Memorandum

Re: Allaso Louisiana Site Plan – DRB Comment Responses (PR-2021-006238)

This memo outlines the responses and changes made to the site plan for the Allaso Louisiana project based on the updated and remaining comments received and reviewed at the January 12, 2022 DRB meeting.

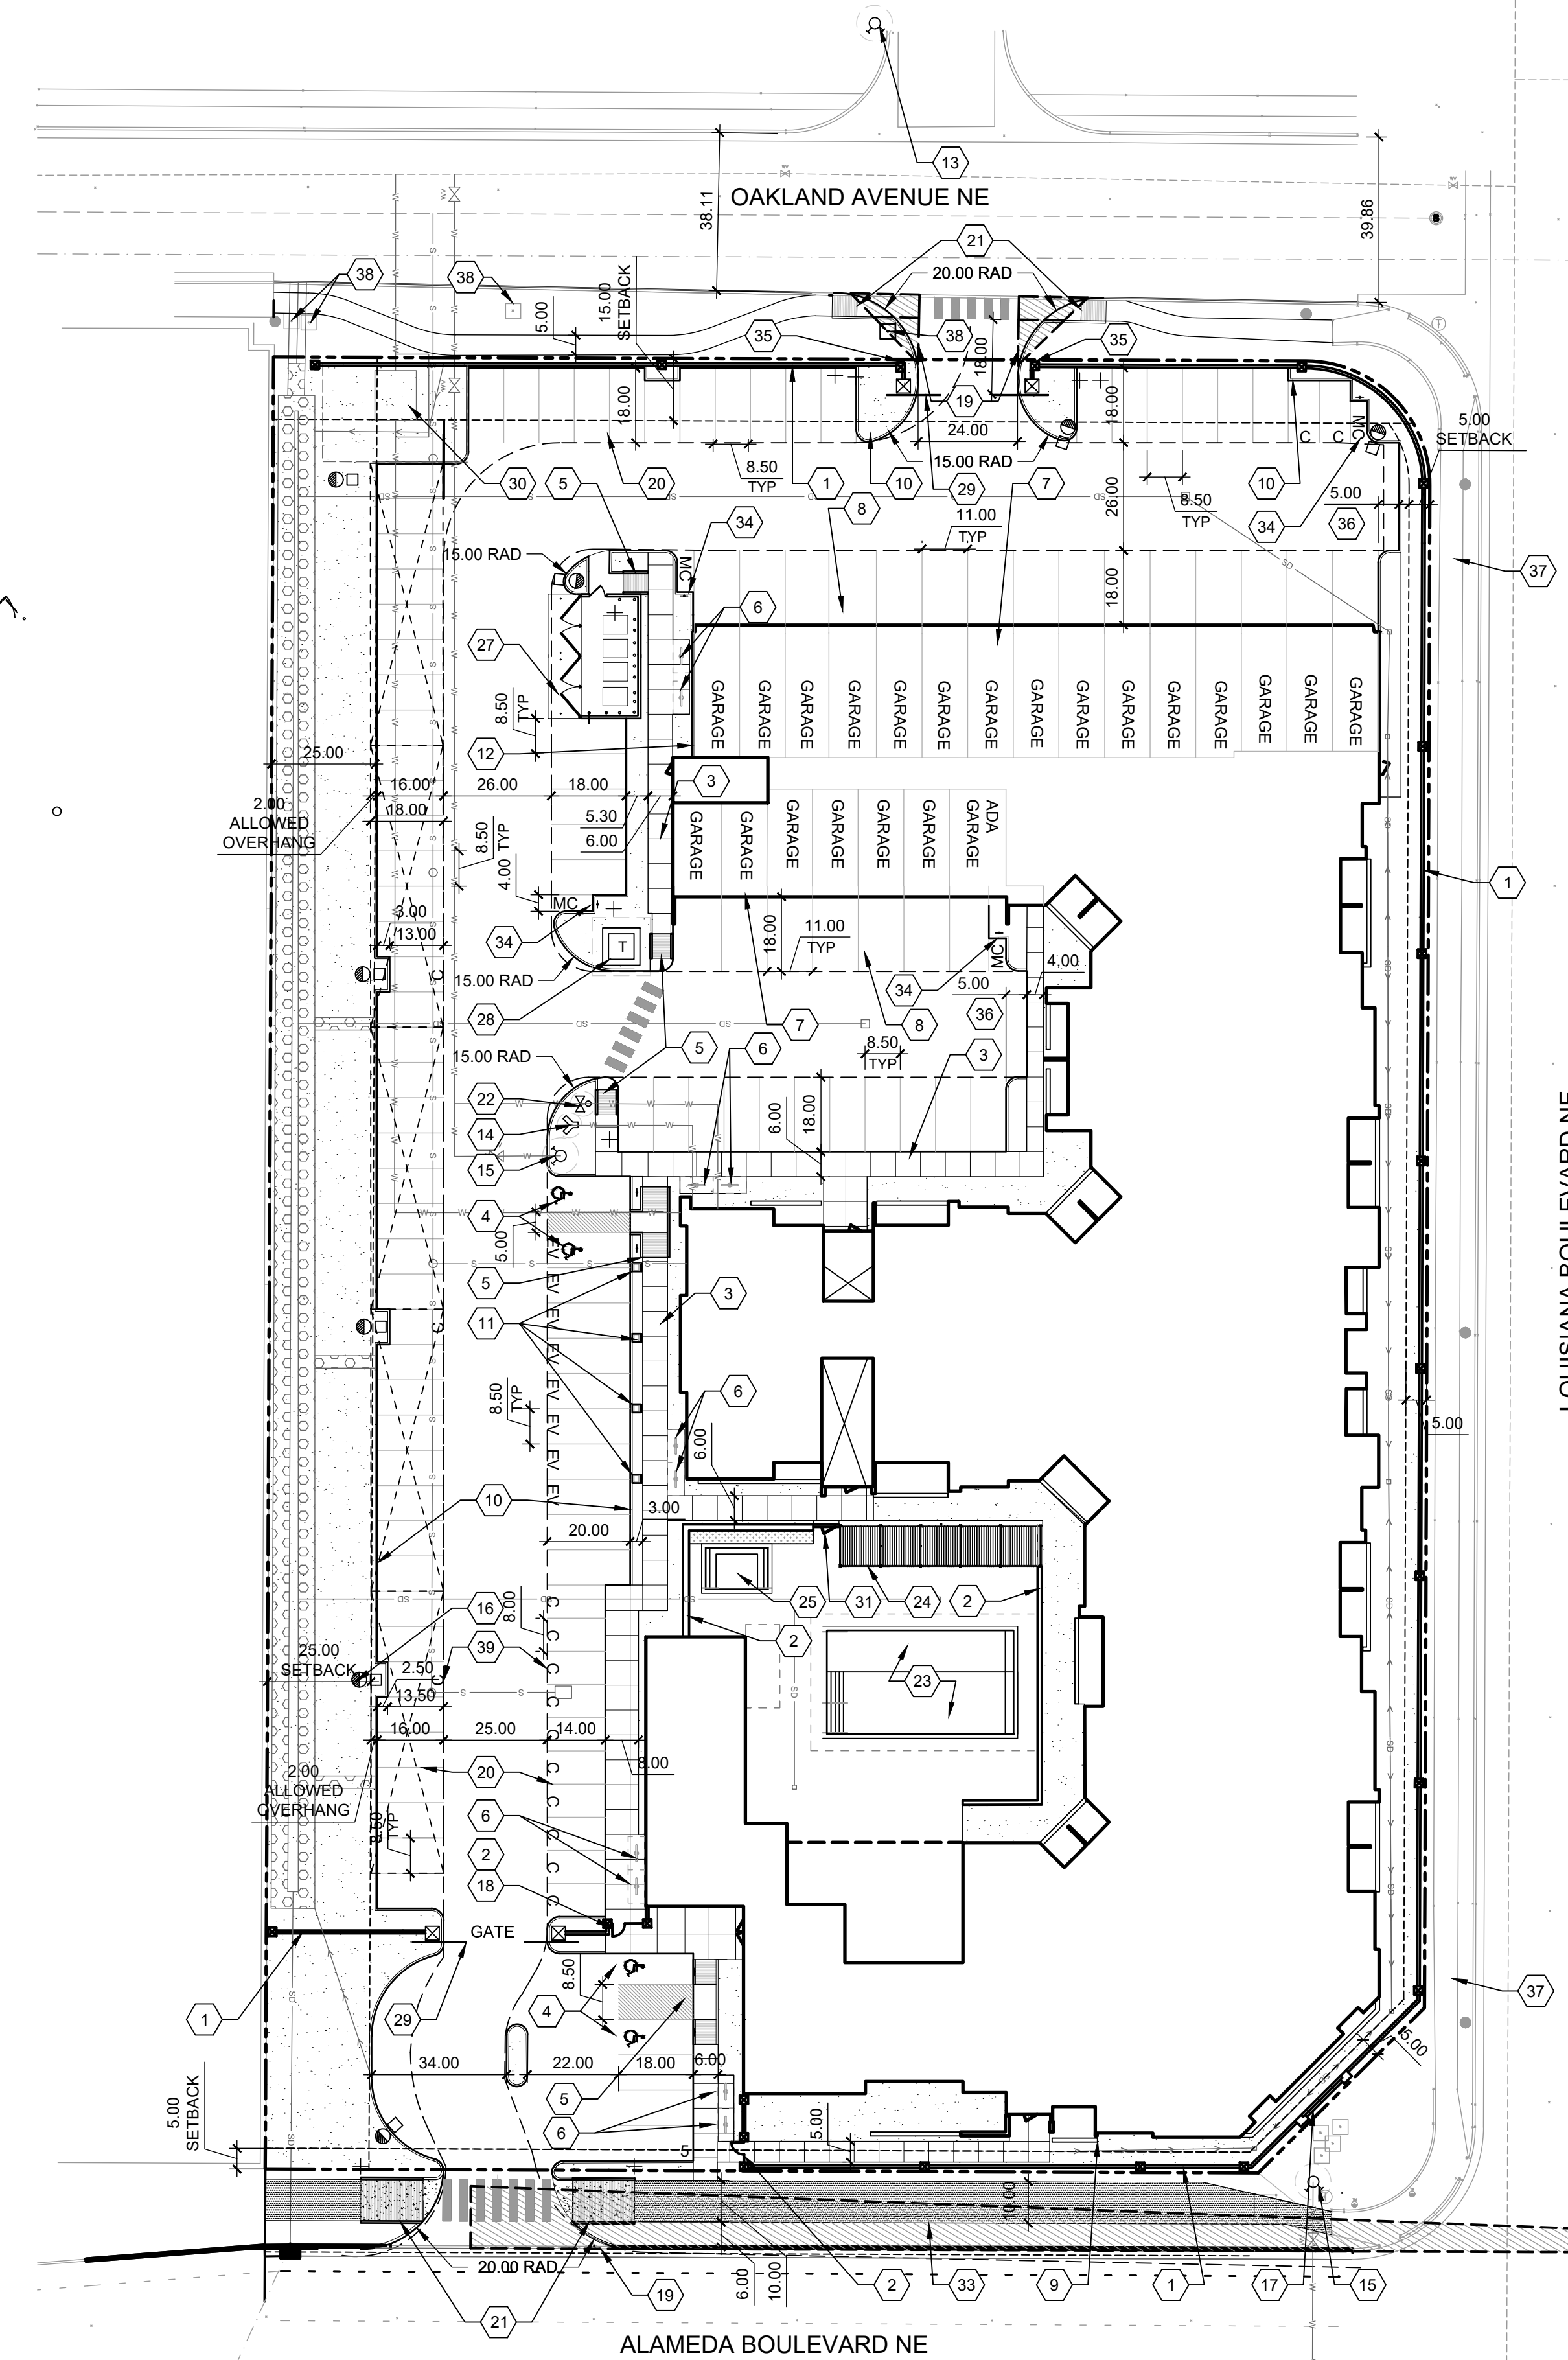
1. Label clear sight triangles with a keyed note on the landscaping plan for both entrance locations.
 - a. ***A keynote has been added to the landscape plan for the clear sight triangles.***

3. Along Oakland Drive, the existing sidewalk on either side of the property has a landscape buffer. Make adjustments to incorporate this buffer except where the entrance way is located.

- a. ***Sidewalk has been redesigned to match adjacent landscape buffer.***
4. On Alameda Boulevard, Note 26 which designates the bus shelter location is shown on the opposite side of the road instead of in front of the site. Shifting of the trail around the bus shelter location with gradual transitioning based upon design speed may impact landscaping plan.

5. Dimension all parking spaces, and make sure dimensions are called out on all segments, including the width.
 - a. ***Additional dimensions have been added to show dimensions of all parking spaces length and width.***

6. If allowing for overhang as part of a standard parking space where the minimum required length is 18 feet, label the overhang on the drawing (west side of parking lot). The maximum number of compact parking spaces in the IDO shall apply.

7. For the compact spaces near the south side of the site, the minimum length is 15 feet, and the minimum required pathway width to the right-of-way is 6 feet. Make adjustments as necessary; if using overhang, label this, and adjust the sidewalk.

- a. ***Sidewalk has been adjusted to 8'-0" wide to allow for a 2'-0" overhang and a 6 foot right of way at the sidewalk.***
8. Label typical width of parking spaces along the west side of the parking lot along both aisles, including the compact spaces.

- a. ***Width of parking spaces has been dimensioned.***
9. Given the number of bicycle spaces actually required, indicate on the site plan where these will be accounted for.

10. The curb ramp on the far north side does not lead to any continuous pathway to the north and appears to not be needed since the ADA connection to the right-of-way is to the south.

11. At the far south entry, shift the median island to the west in order to allow for sufficient vehicular maneuvering around the east side of the island and to allow for sufficient space for backing up the vehicles to the east of the island. Ensure that vehicles will be able to turn around the island.

- a. ***Island median has been shifted to accommodate cars backing up from parking spaces and full turn around space around the island.***
12. Use keyed notes to designate the handicapped spaces, signage, and ramps on the south side of the site.

- a. ***As discussed at the DRB hearing on 1/12/2022, CABQ Transit has requested that the bus shelter be located on the south side of Alameda as shown. No modifications made.***

- a. ***Overhang has been dimensioned, parking space is 16'-0" and overhang at curb is 2'-0" for a total of 18'-0".***

- a. ***Bicycle parking is required for 16 bicycles. 20 spaces are provided through 10 two-sided bike racks, see keynote #6. Each leader line from the keynote indicates a bike rack. See legend and keynote description for more information.***

- a. ***The curb ramp provides access to the trash enclosure for residents of the complex via an entry into the enclosure on the north side. See associated enclosure detail. The ramp and pathway have been left as-is to maintain this access.***

- a. ***Additional keynotes have been added for these items.***

LS-01

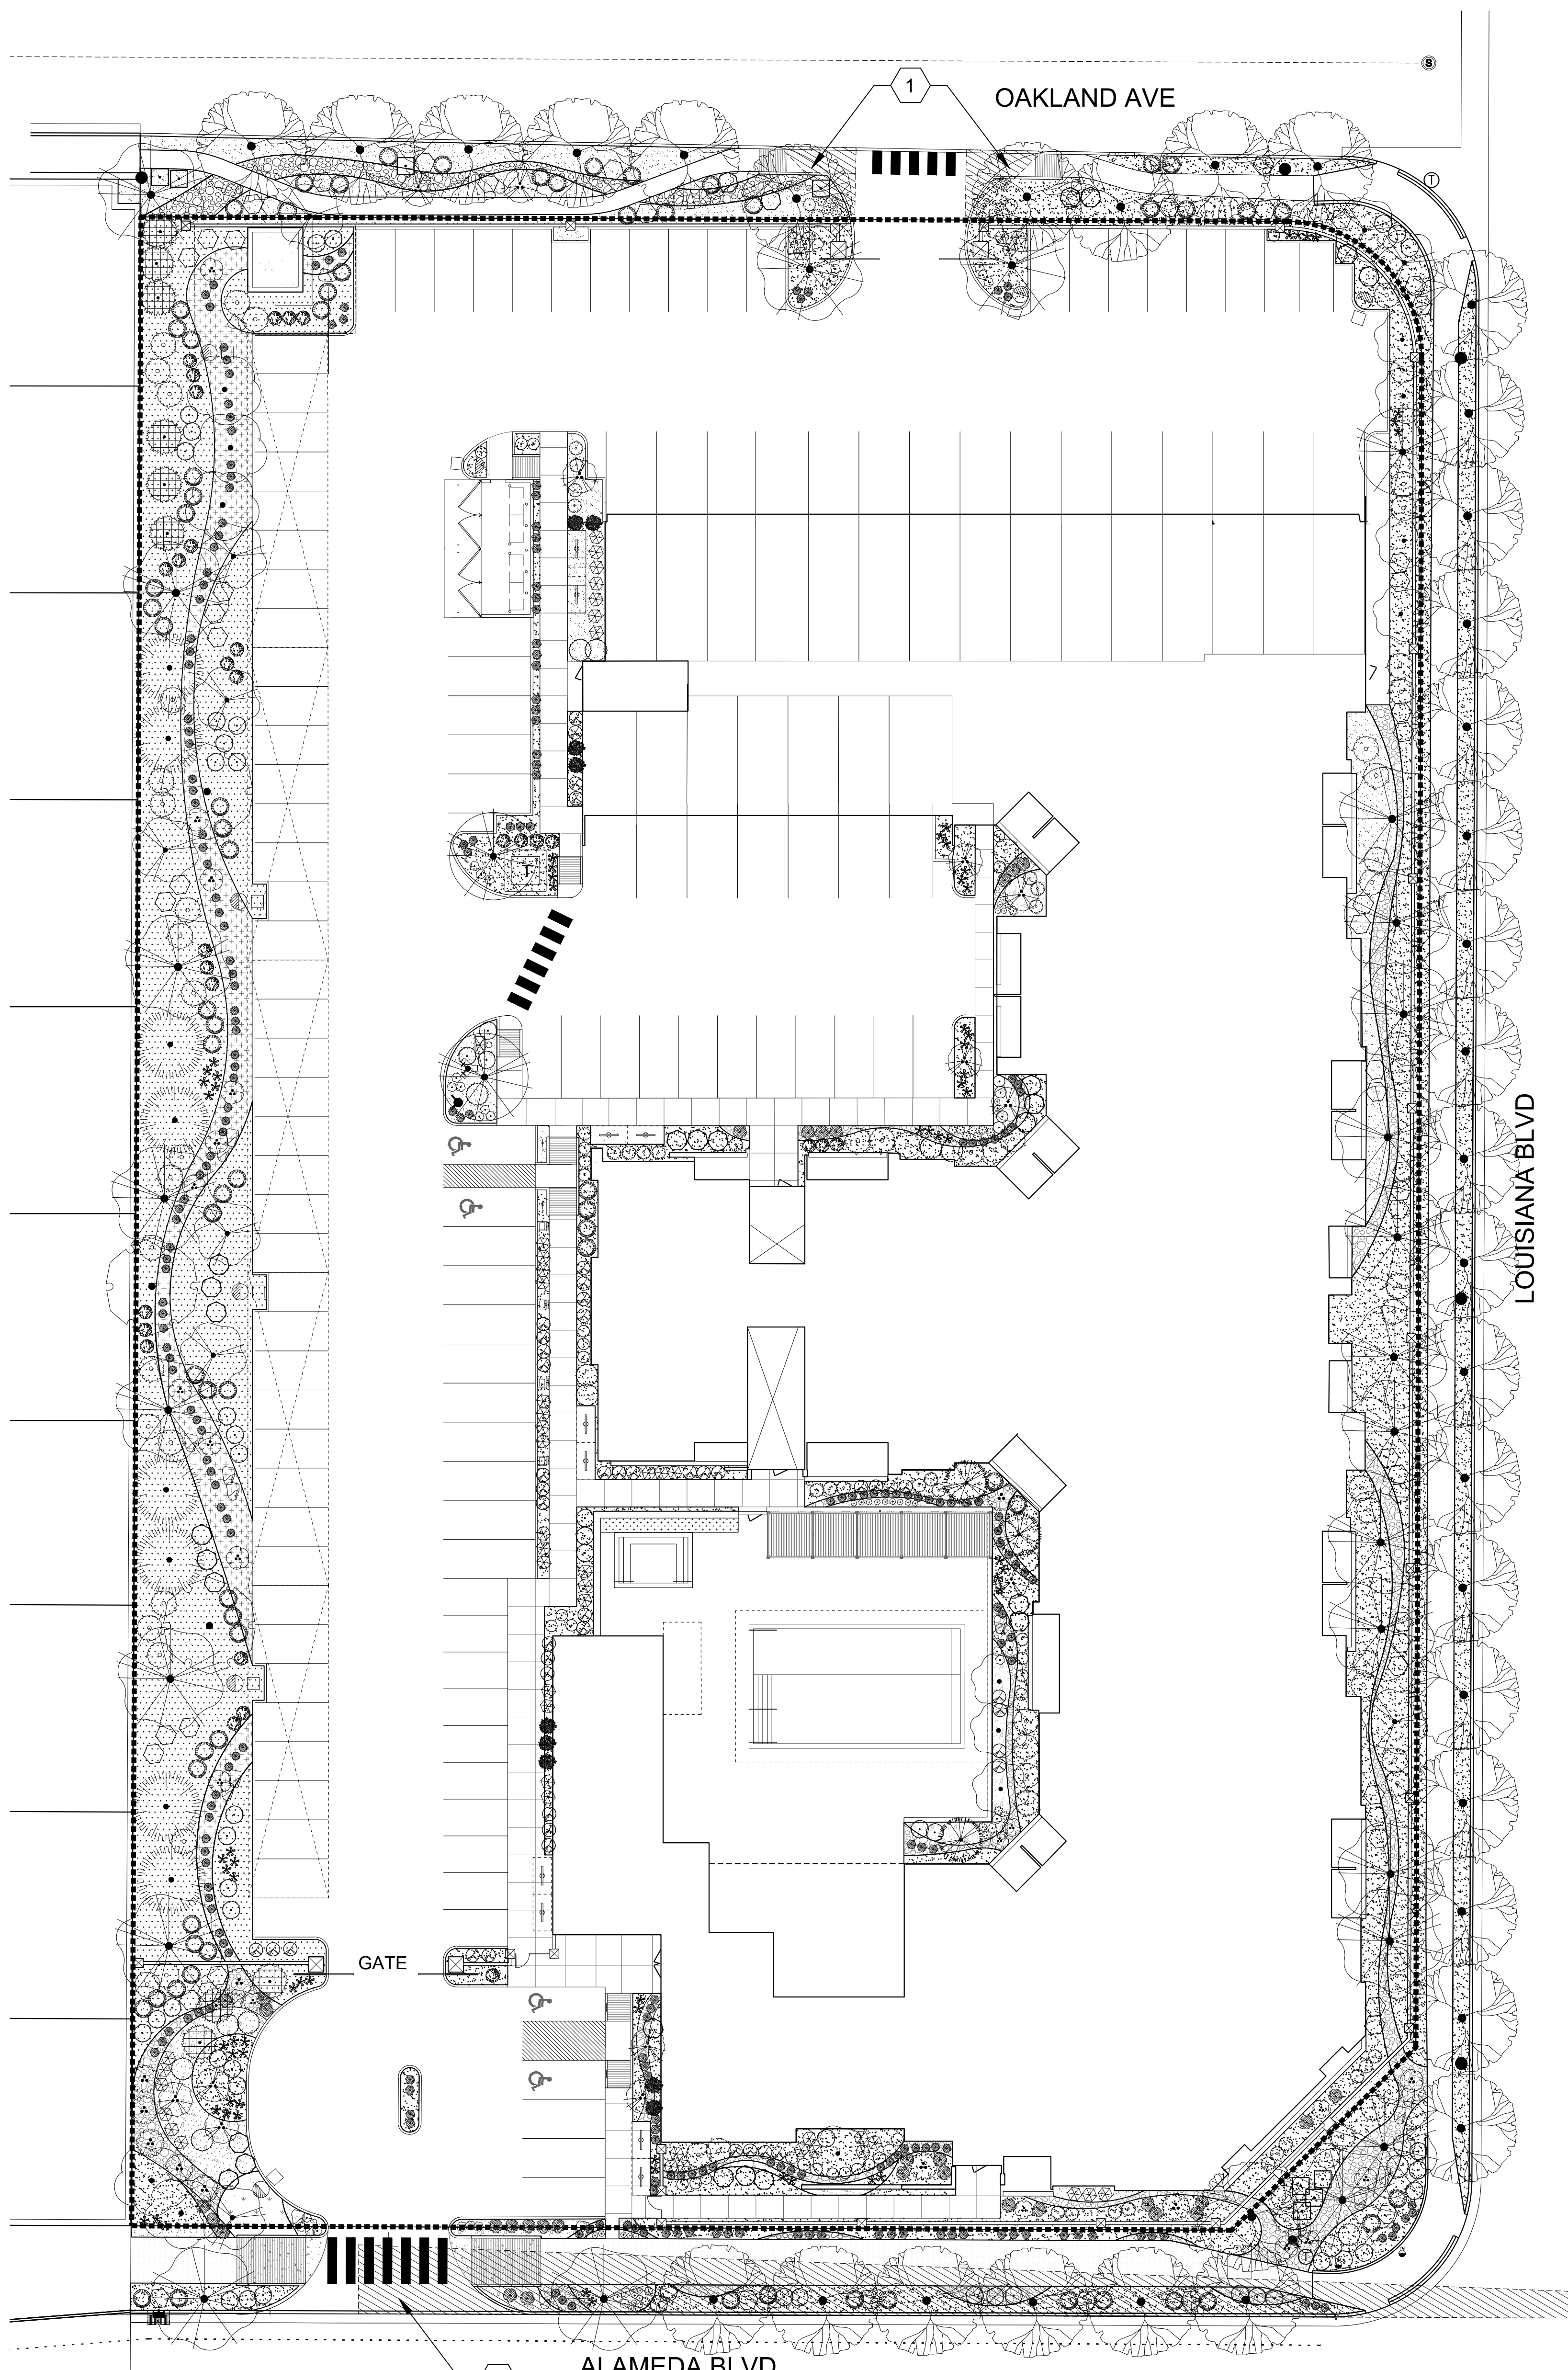
4. Utility Plan:
 - a. There shall be no trees, parallel fences/sidewalks/curbs, or structures within the public water and public sewer easement. Please revise landscape plan in the area of the water meter vault.
 - a. ***The landscape plan has been updated to further adjust the landscaping around and within the easement area.***
